El Paso County Planning and Community Development

Re: Windermere Final Plat (SF-21-026)

Please accept this response letter to comments received October 19, 2021

SST

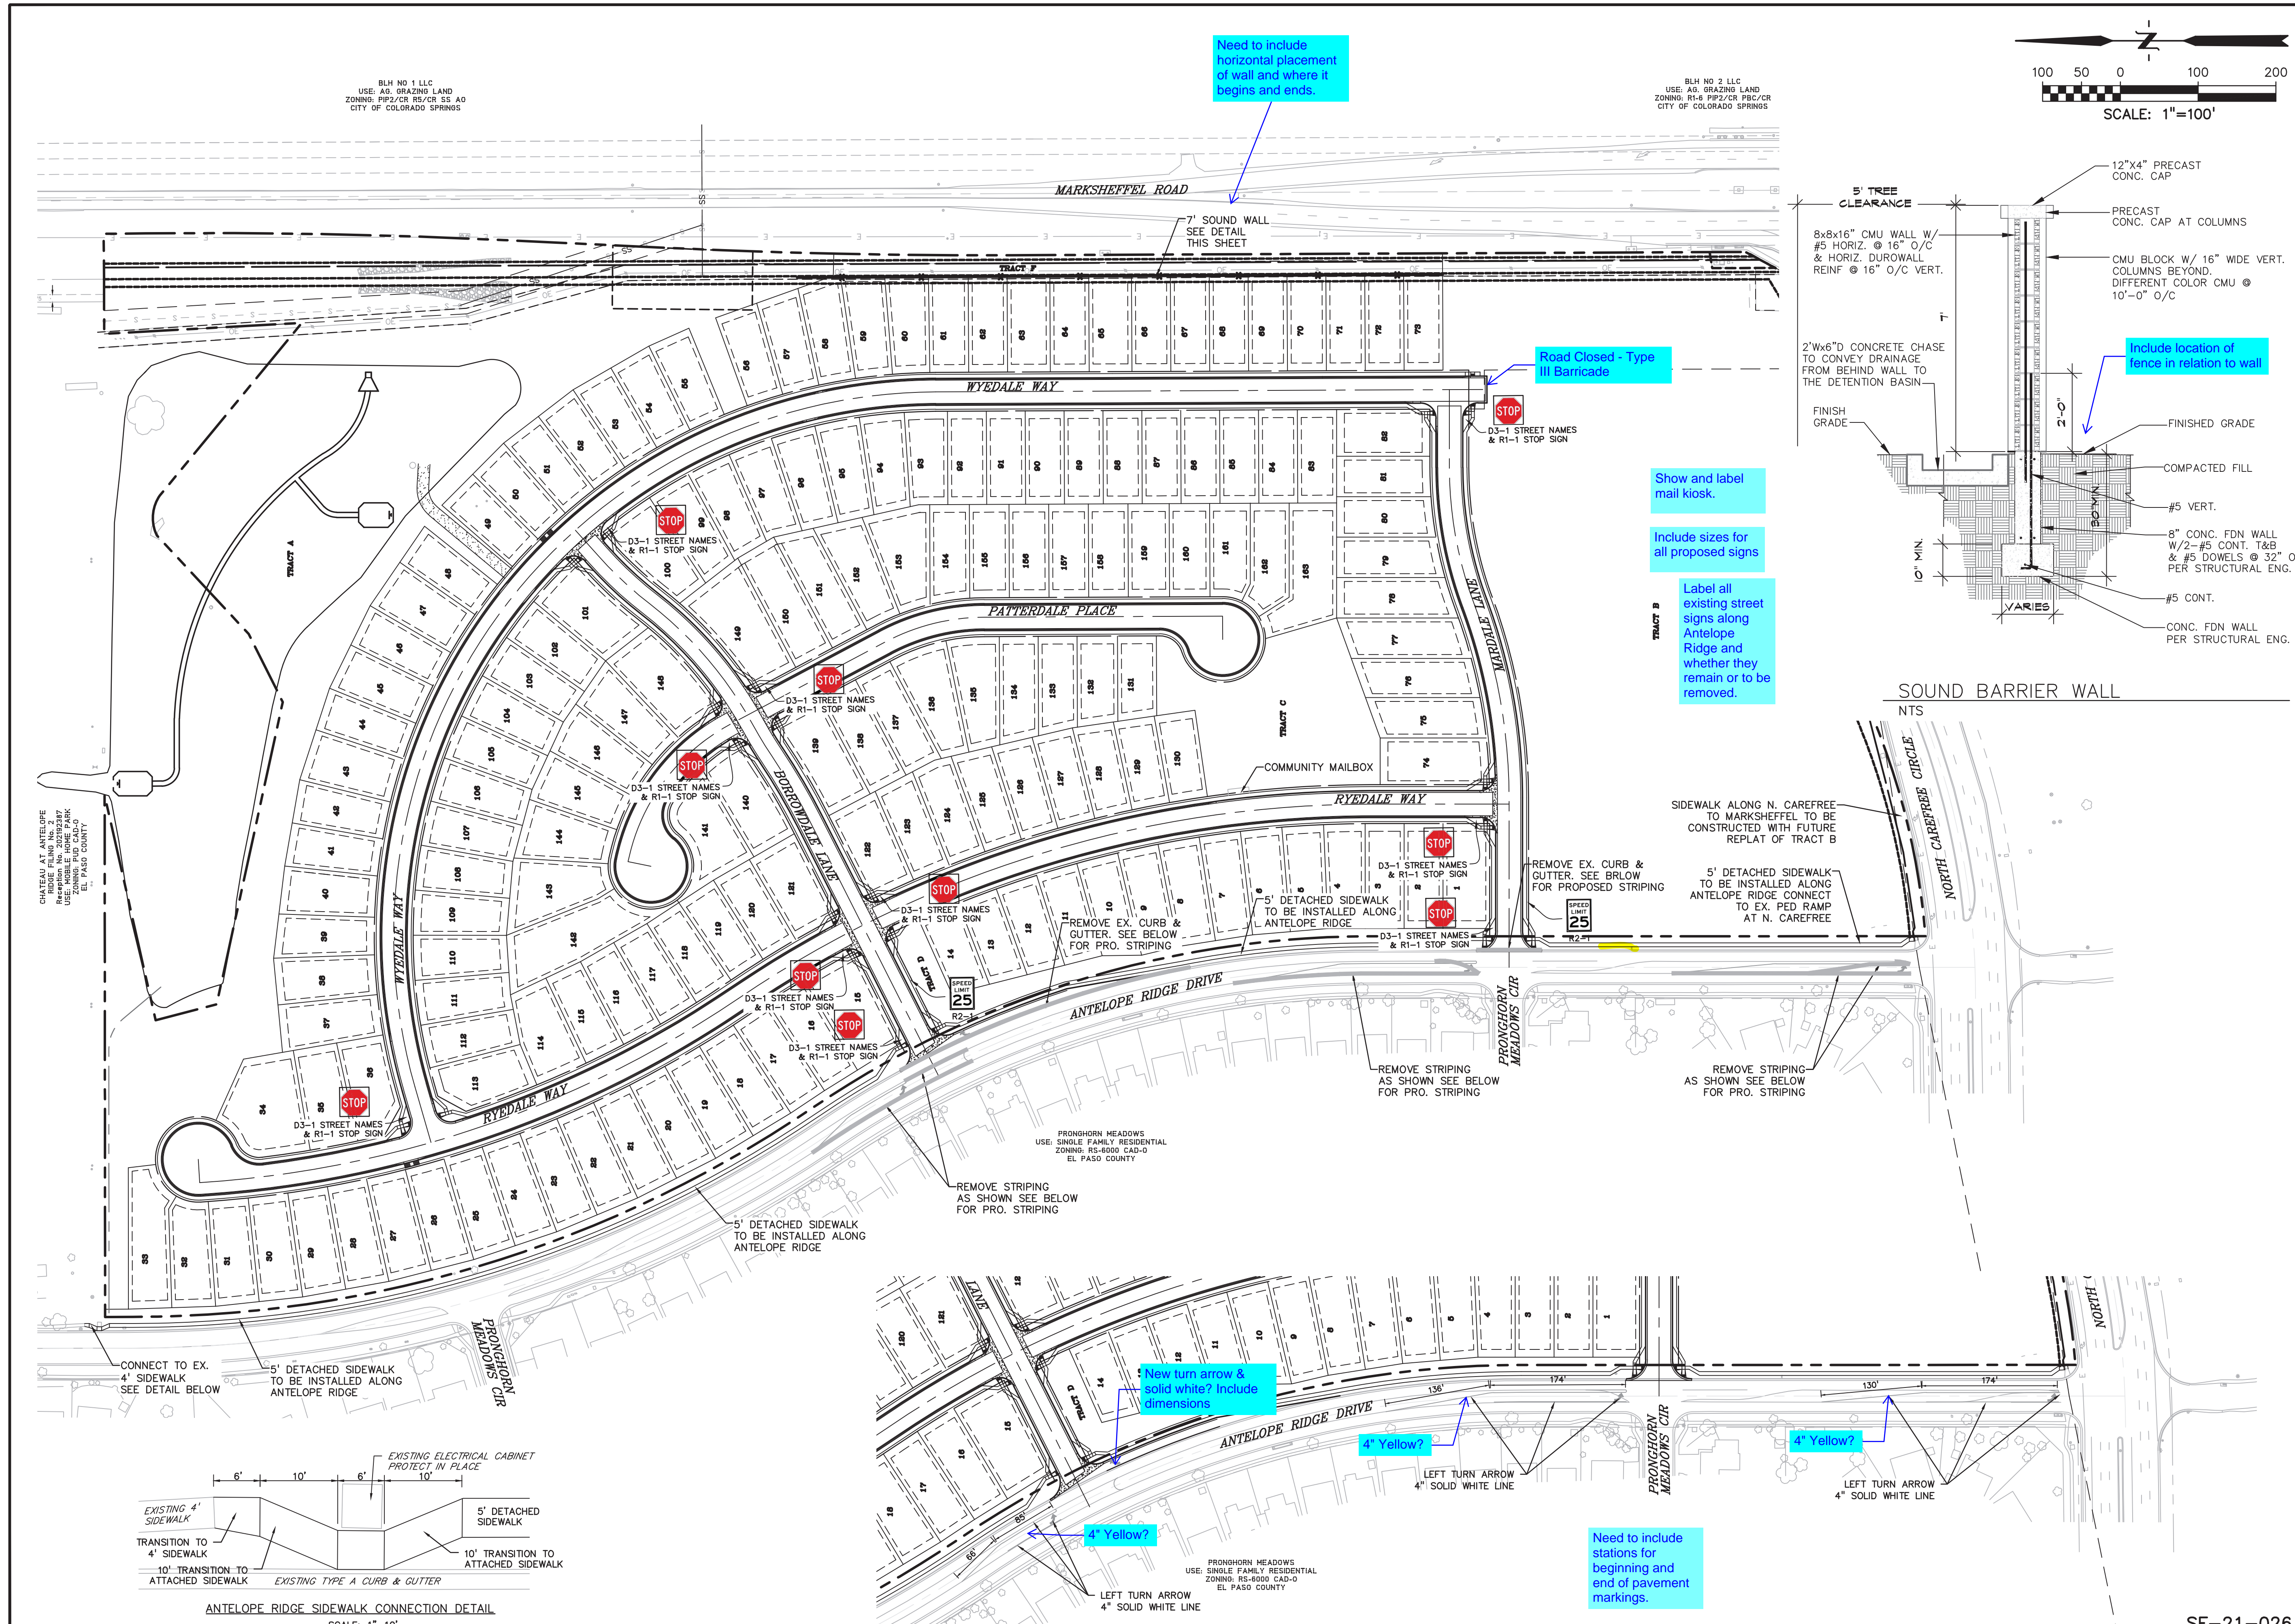
1. See cursory CD redlines; design revisions and additional details are needed. *SST (sheet 5) – additional notes added for the sidewalk along Antelope Ridge. RD07 (sheet 12) – too much grade to wrap sidewalk around Lot 33 and out to Antelope Ridge. Detail of sidewalk connection to existing added to sheet SST. RD18 (sheet 23) – sidewalk linetype revised. Further notation added to inlet. INT4 (sheet 28) – mailbox is on Ryedale Way side of Tract C and is shown on RD10.*

RD10

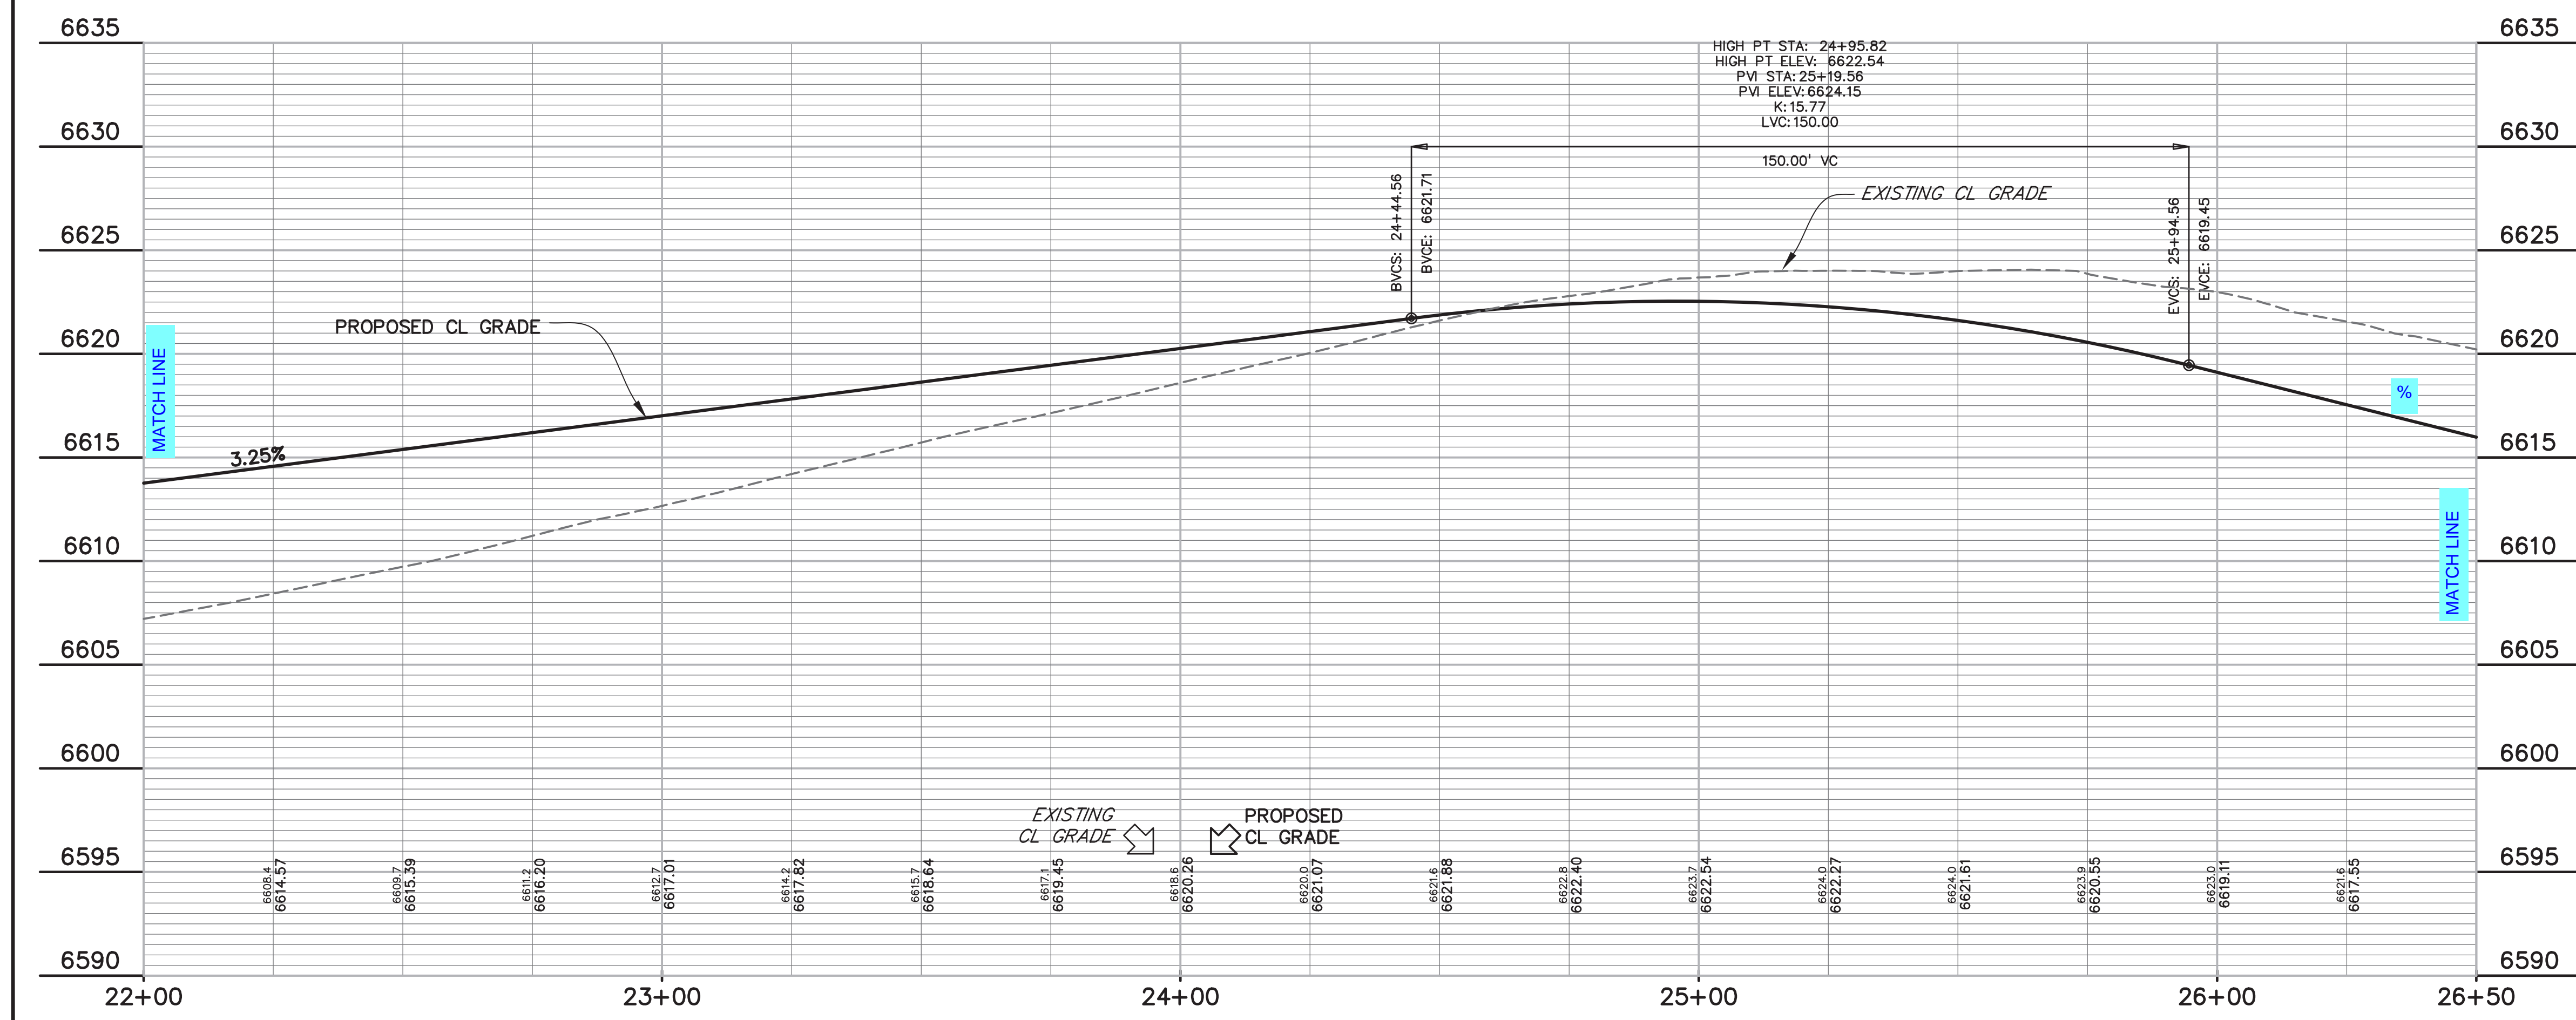
4. **Resolved.**
5. If there will be USPS mail kiosk/cluster(s) in this subdivision provide location(s) and details. **Unresolved – see redlines.** *Shown on RD10 (Wyedale Way side of Tract C)*
